Consultation Response: Kirklees Council Conservation & Design (Trees)

Date	<i>14 June 2018</i>
Officer responding	<i>Nick Goddard</i>
Application number	<i>2018/91576</i>
Purpose	<i>Initial consultation response</i>
Location	<i>15 Old Mill View, Dewsbury</i>

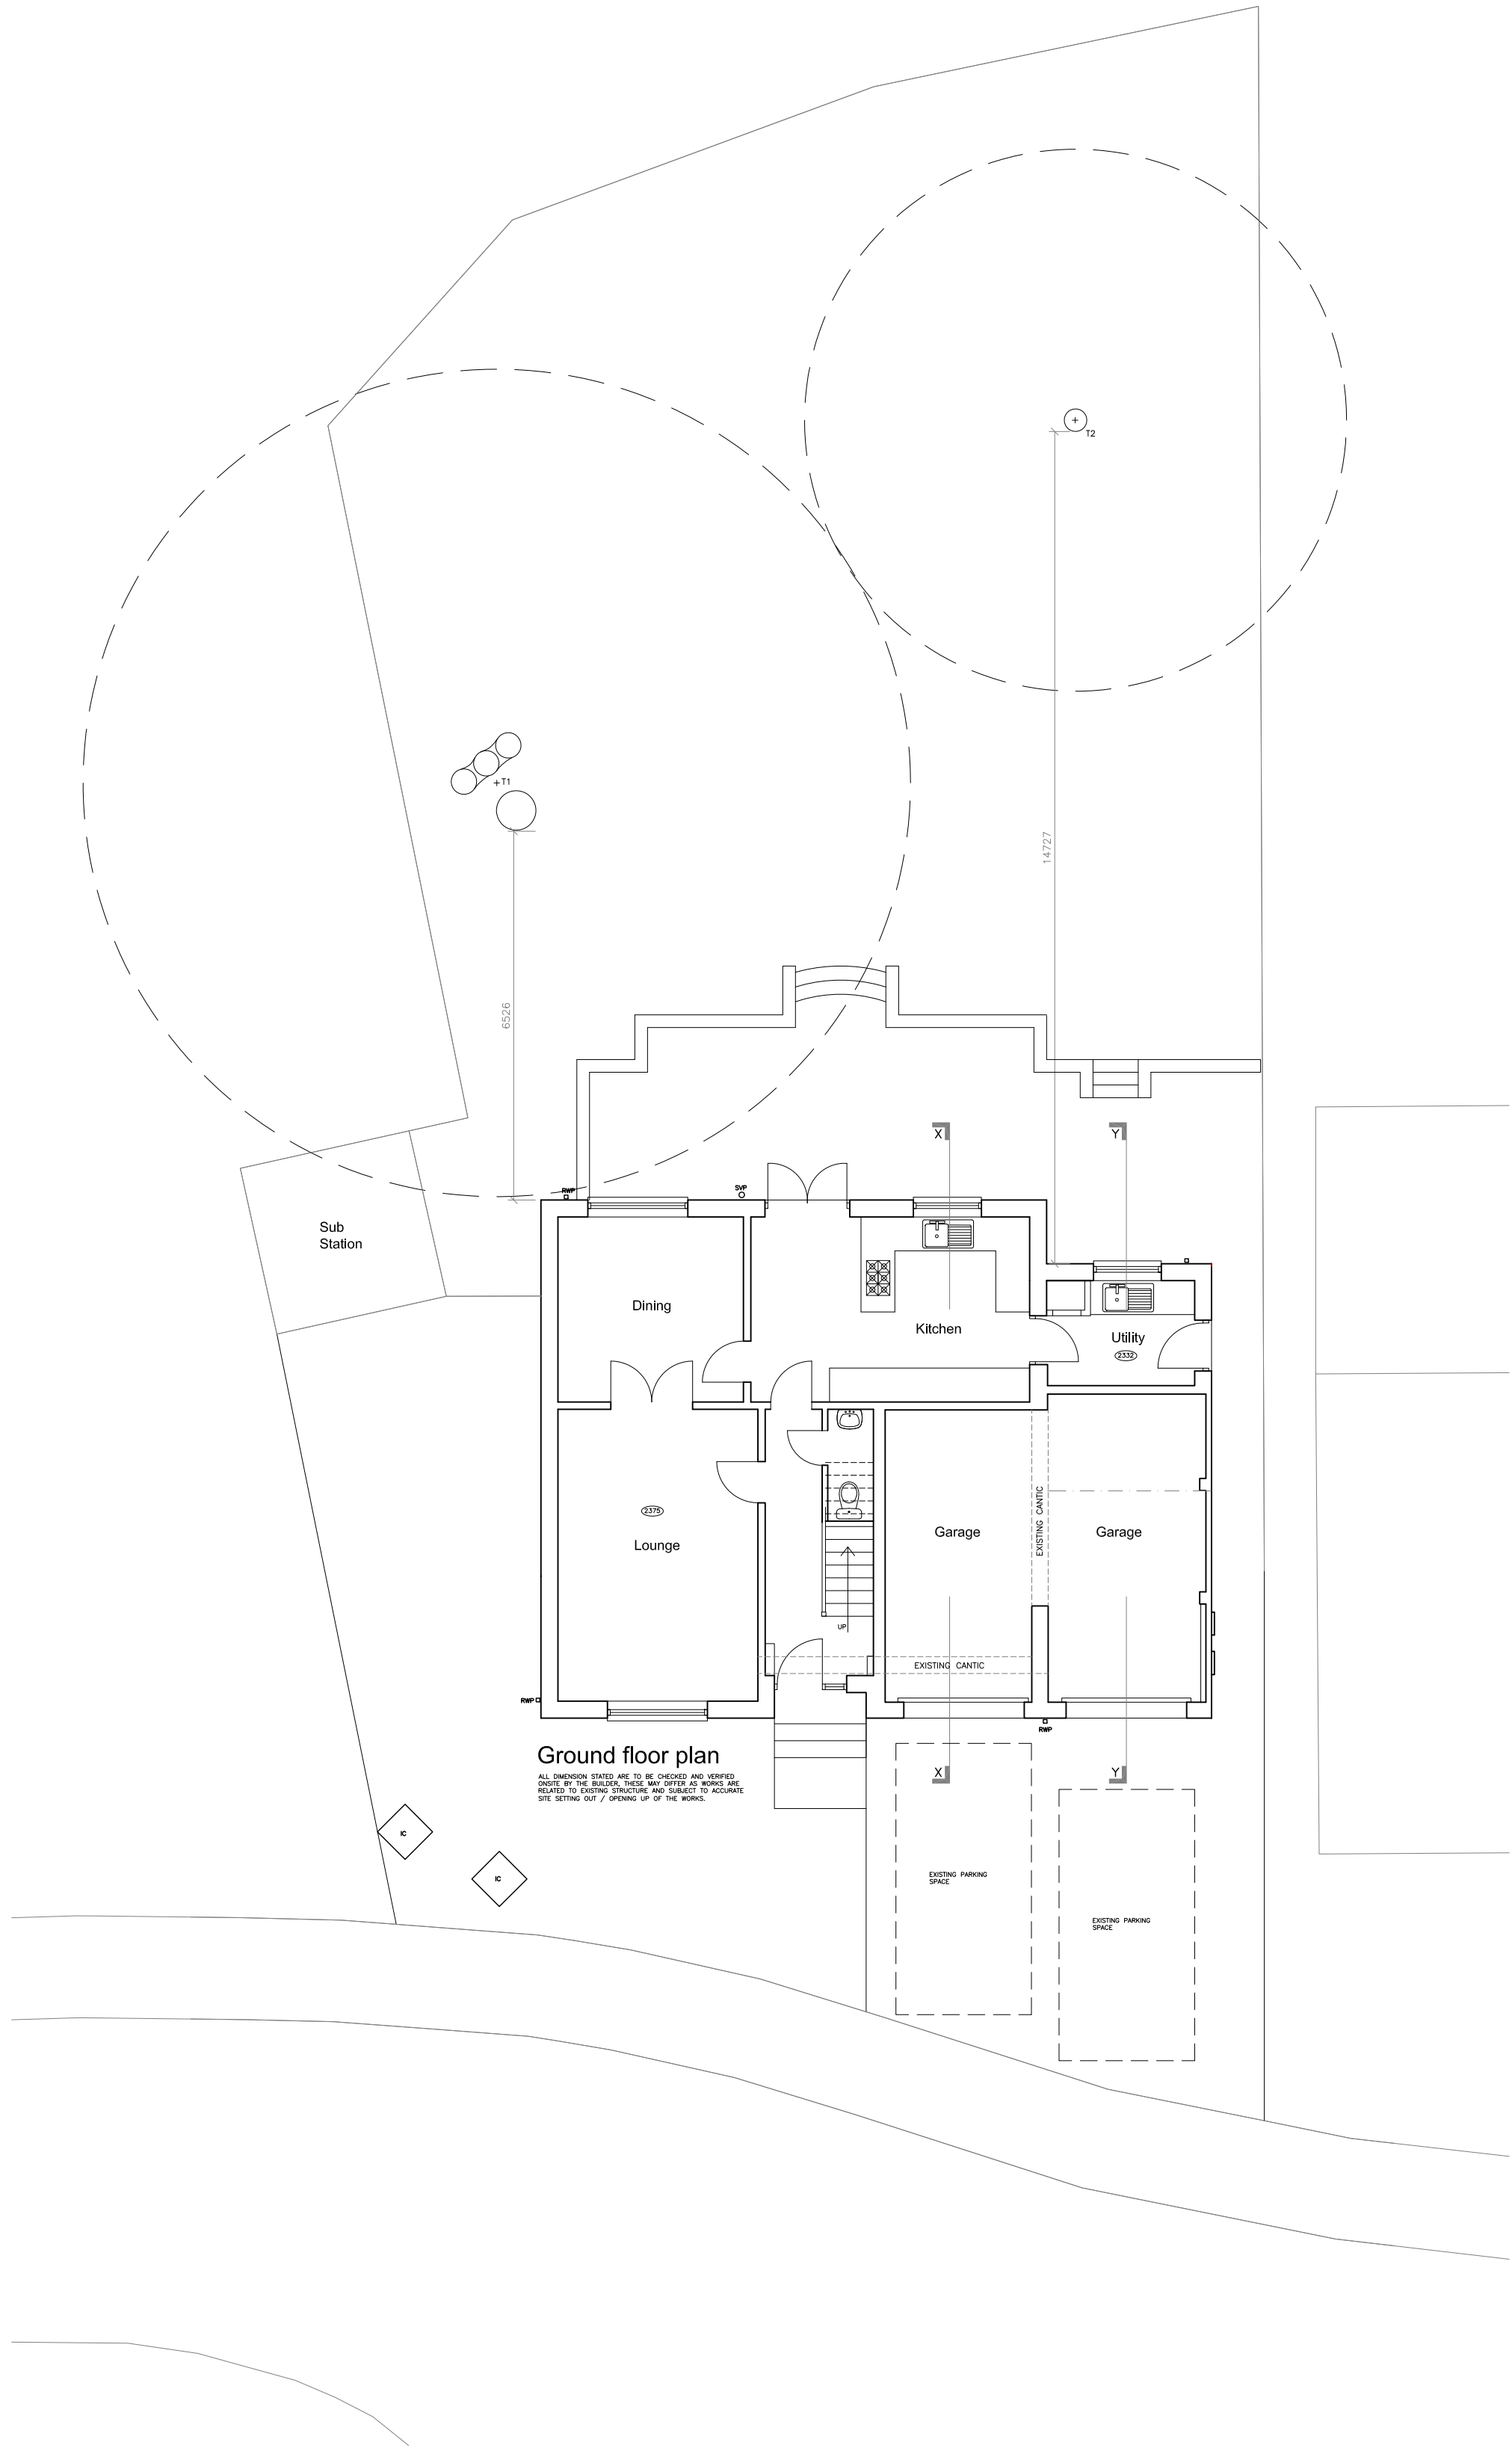
The proposals are to extend upwards on top of a HHPD approved ground floor extension and to alter the roof line and add a new gable end with windows facing the rear garden.

The trees in the rear garden are protected by TPO 14/88. The tree closest to the property has been the subject of 2 recent applications to fell the tree. Allowing this property to be made bigger and therefore closer to the protected trees would, it seems only logical to assume, increase this pressure to fell the trees resulting in its untimely removal.

If I had been given an opportunity to comment on the HHPD application I would have made comment that because this property is already in conflict with the trees in the garden with regards to leaves, light loss, moss and sap fall it would seem inappropriate to extend it further.

With regards to the construction of the HHPD approved extension, it is worth noting that this consent does not give the applicant the right to prune or damage any of the protected trees' branches or roots. For any such work we would require a Tree Work Application which we have not received and therefore not been able to assess whether it can be constructed without causing significant damage to or loss of trees.

I cannot support this application, and it doesn't meet UDP policies NE 9,(PLP33) mature trees to be retained, or BE2, (PLP24i) existing trees to form an integral part of the design.
